### About the application

Application number: 2023/91896	
What is the application for?:	Change use of dwelling to day nursery
Address of the site or building:	Poplar House, 35, Old Lane, Birkenshaw, BD11 2LA
Postcode:	BD11 2BA

Nursery

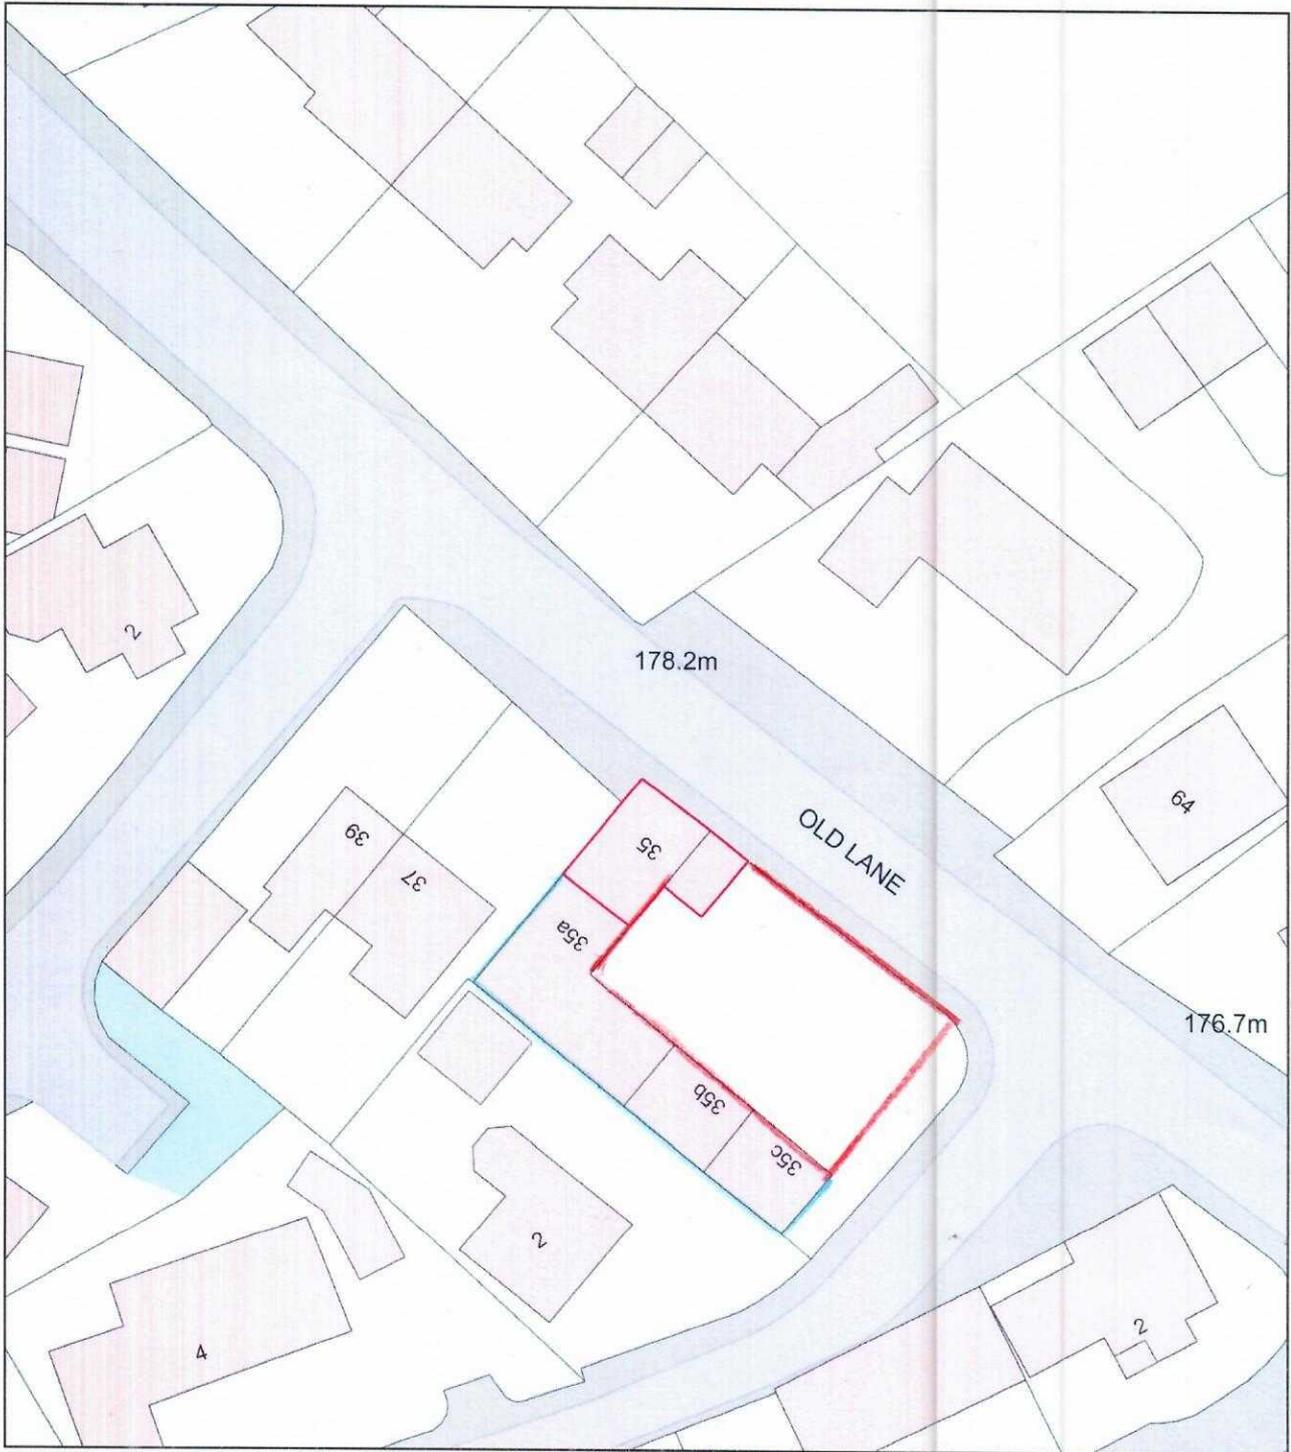
Type of comment: An objection	
Do you wish your comments to be published on the website anonymously?	No
<p>There does not appear to be any area in the court yard that shows parking or space for the staff or drop off / pickup This would indicate that the road will be used for parking, causing limited road view when leaving my property.</p> <p>At present there is no indication how the outside court yard is to be modified for children to play in so limited information on what type of barriers will be erected to comment on.</p>
